Appeal Decision

Appeal Ref: APP/A2525/W/19/3227640

The Fitness Company, 38 Spring Gardens, Spalding PE11 2XL

- The appeal is made under section 78 of the Town and Country Planning Act 1990 against a refusal to grant planning permission.
 - The appeal is made by Minster Building Company against the decision of South Holland District Council.
 - The application Ref H16-0469-18, dated 14 May 2018, was refused by notice dated 20 March 2019.
 - The development proposed is described as the 'change of use of the existing building from use class D2 to use class C3, to include one 1-Bedroom apartment and eight 2-Bedroom apartments, proposed new four storey apartment building including twelve 1-Bedroom apartments, and associated external works and infrastructure.
-

**Proposed Ground Floor Layout / Site Layout:**

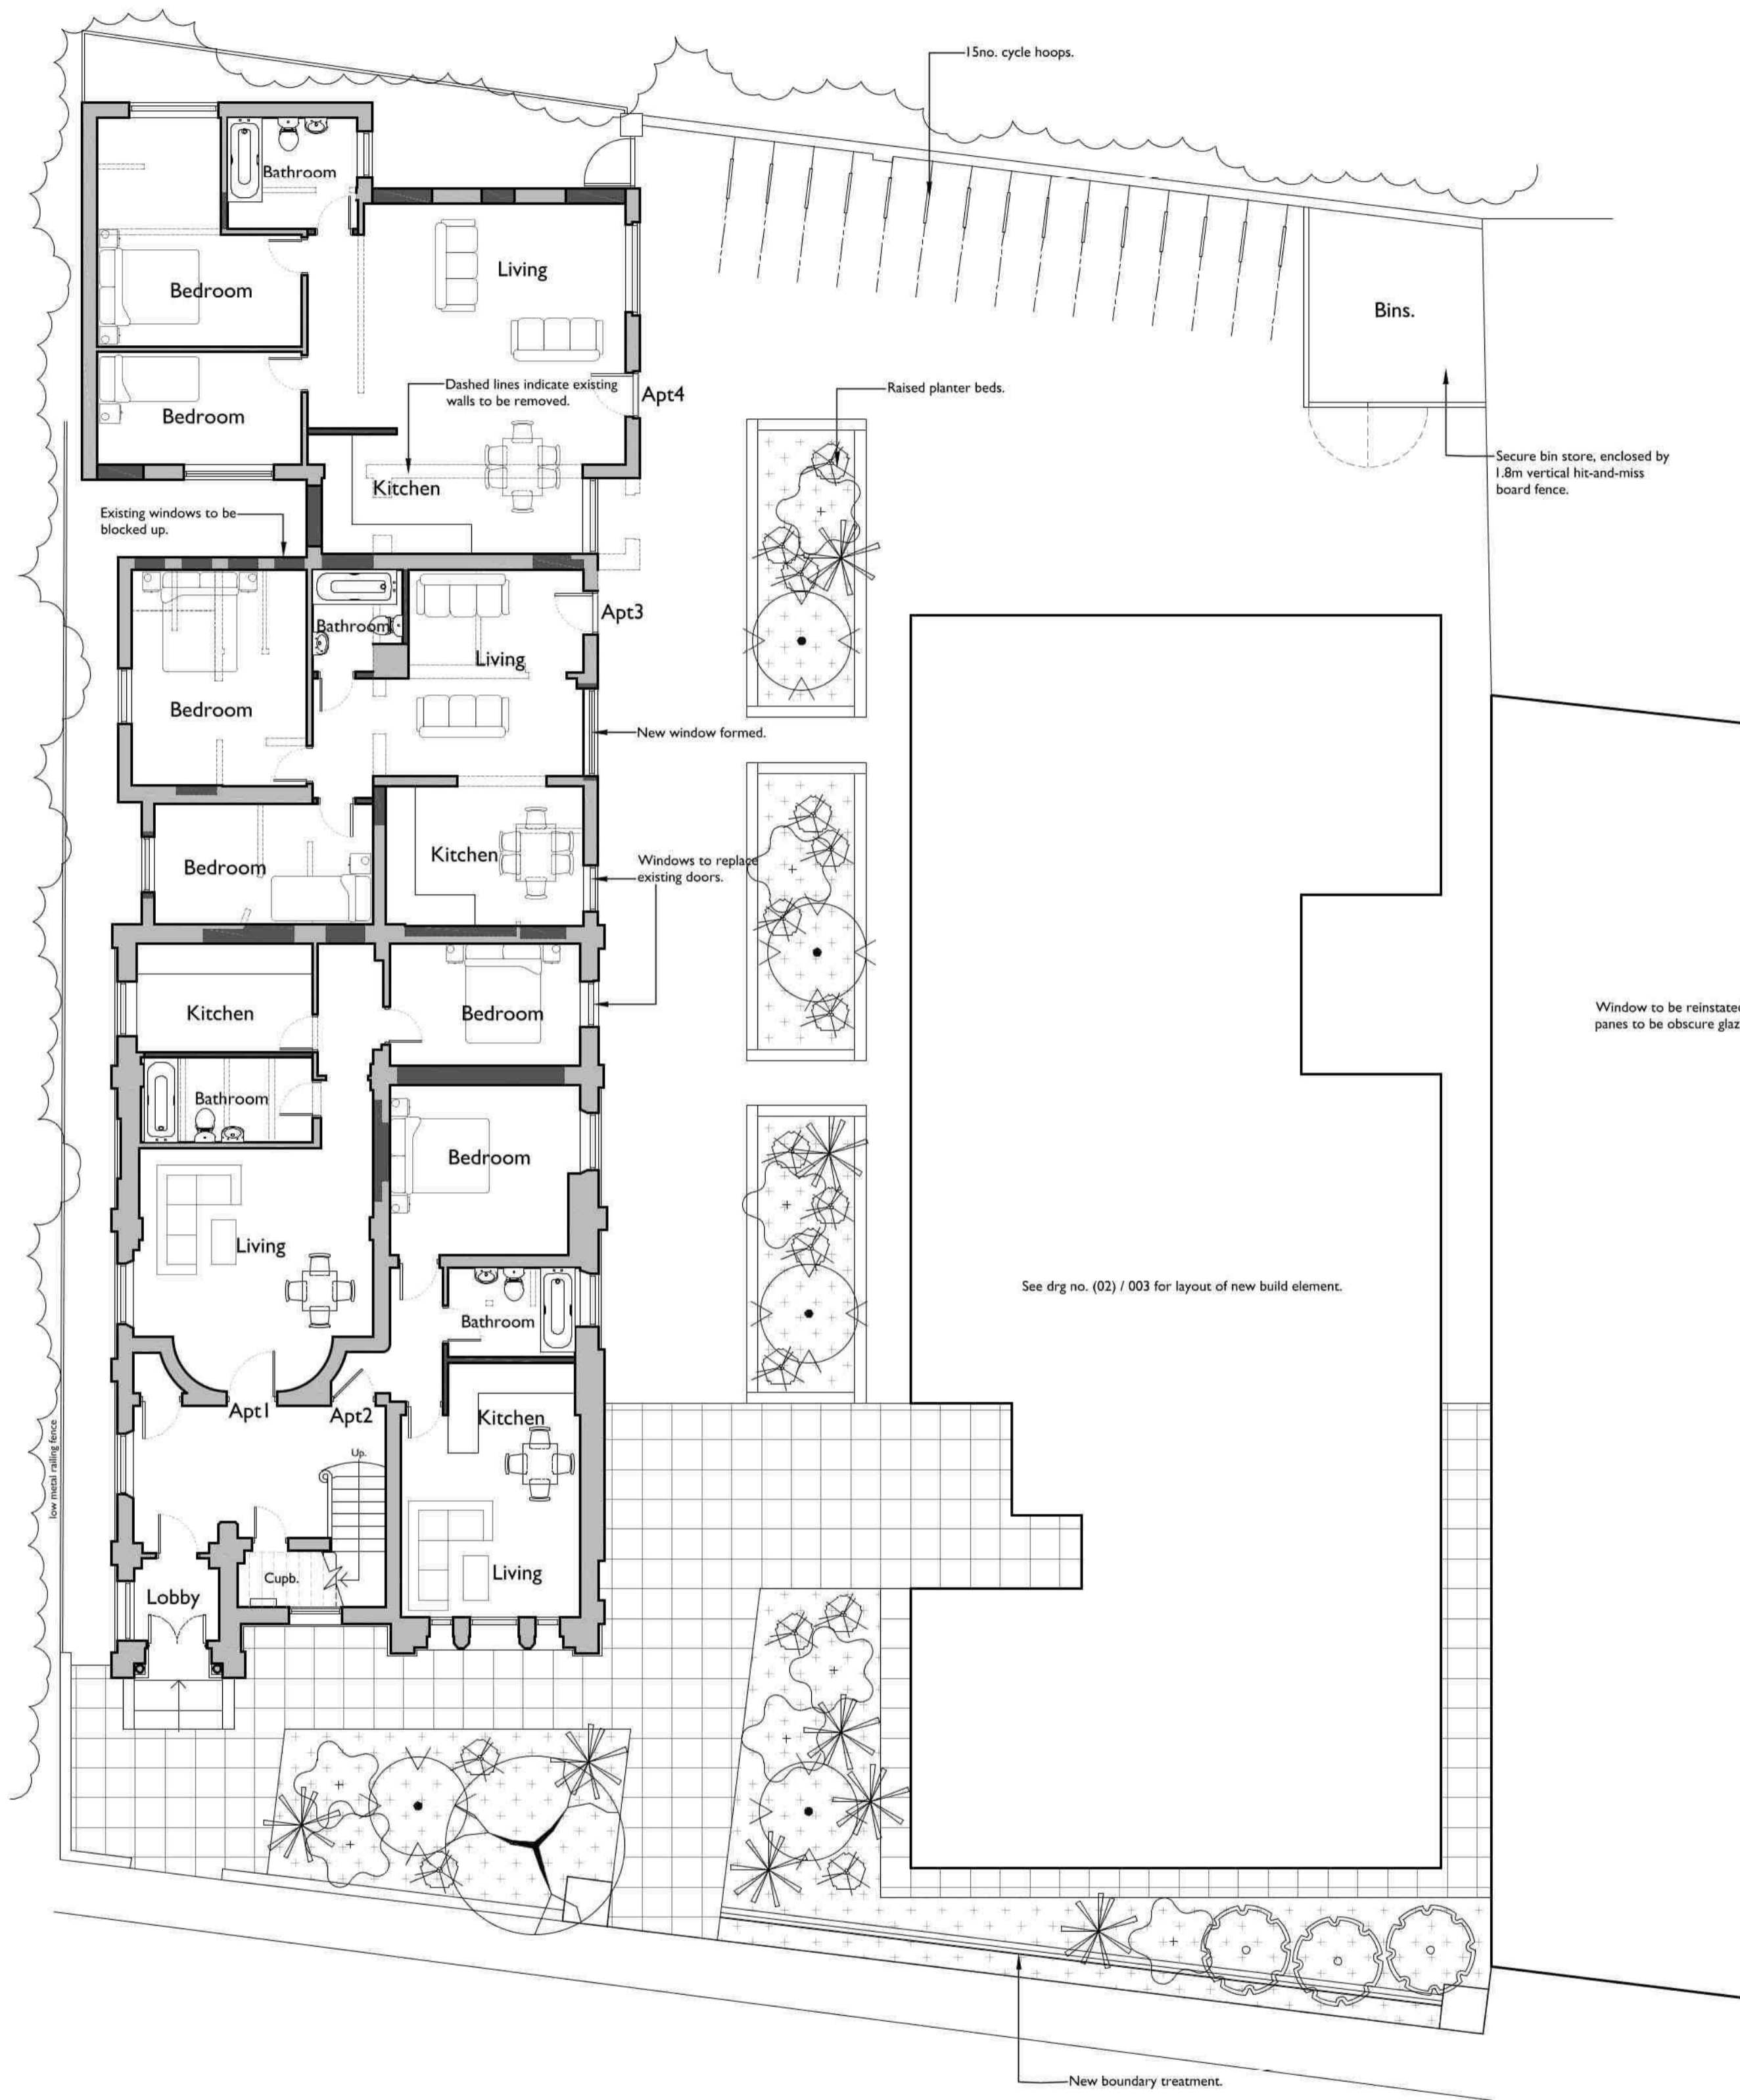
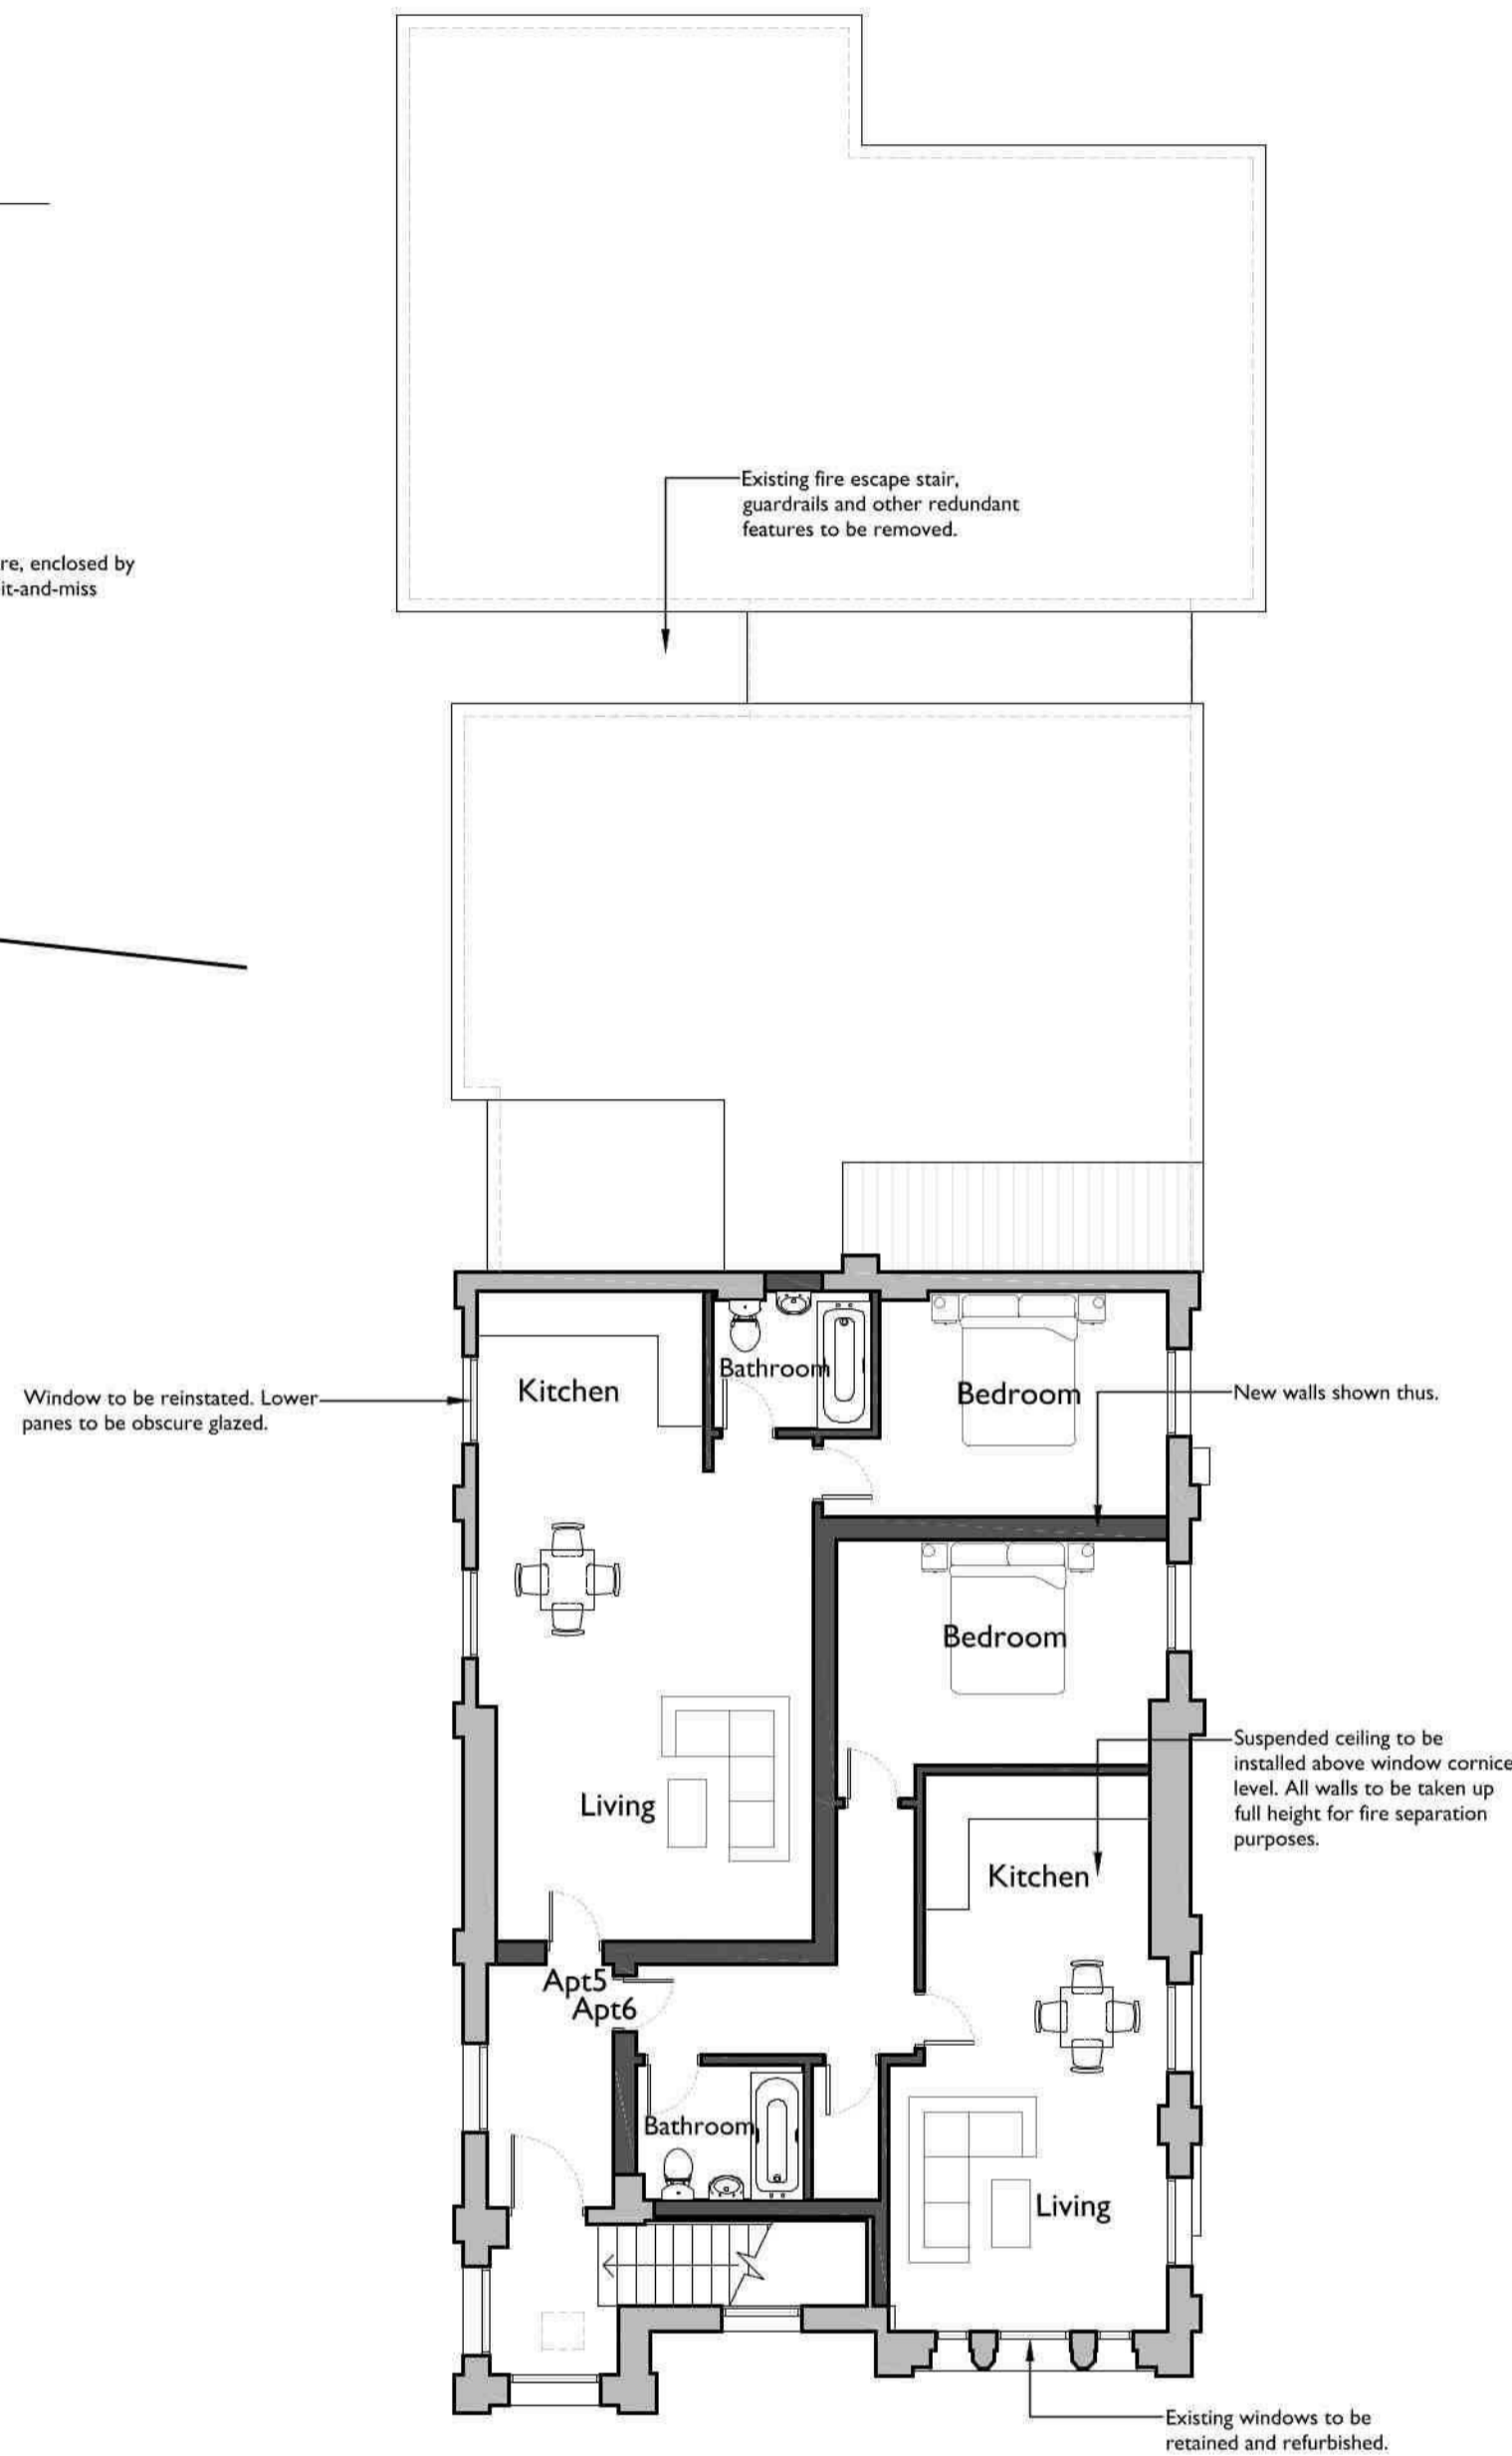
23. The reason for refusal also refers to the proposed arrangements for refuse/recycling storage and considers that collection would be harmful to the amenity of the area. The appellant explains that a dedicated bin store, as shown on the plans, be managed and maintained by a housing association (or similar) who would take responsibility for moving bins to and from the highway on collection day and generally ensuring that the bin store is clean, tidy and secure. Such an arrangement could be ensured by condition, and I do not consider that the scheme would cause harm to the amenity of the area and would comply with Policy 3 of the Local Plan in this regard which states that development proposals will demonstrate how the provision of facilities for the storage of refuse/recycling bins will be secured.
